From: Plant, Tom - Communities <Tom.Plant@Oxfordshire.gov.uk>
Sent: 11 March 2021 19:00
To: Shona King <Shona.King@Cherwell-DC.gov.uk>
Cc: Transport CDC Minor <Transport.CDCMinor@Oxfordshire.gov.uk>; Planning <Planning@Cherwell-DC.gov.uk>; Cllr Carmen Griffiths <Carmen.Griffiths@Oxfordshire.gov.uk>
Subject: 21/00369/F - Kirtlington Post Office Stores 1 Troy Lane Kirtlington OX5 3HA

Planning application:	21/00369/F
Location:	Kirtlington Post Office Stores 1 Troy Lane Kirtlington OX5 3HA
Description:	Change of use of shop to residential, alterations to rear of property, alterations to front window and two new roof lights (Re-submission of 19/02888/F)
Type:	Full Development
Case Officer:	Shona King

East Elevation (Rear) As Proposed
1:100@A1

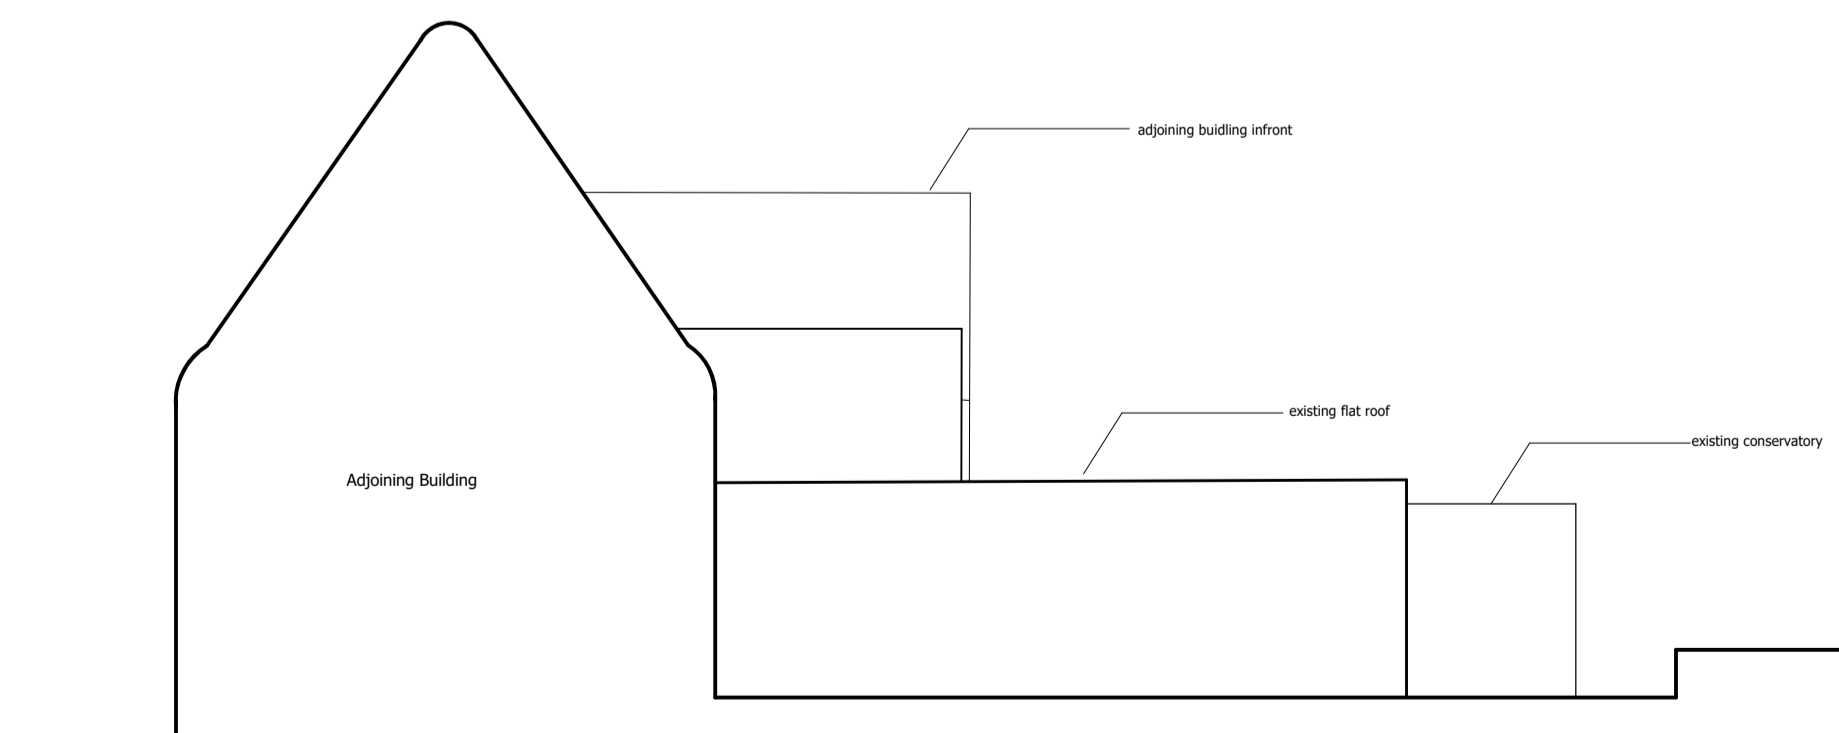
I have viewed the current submission, supporting statement, and amended plans which show a door replacing a window in the rear ground floor elevation. I have not however seen anything within the current submission that would alter the view that I came to in the below response from January 2020. Therefore, in this instance, taking into consideration that the retail element of the site will cease to function, what on-street parking that could have been utilised previously by passing traffic to the retail
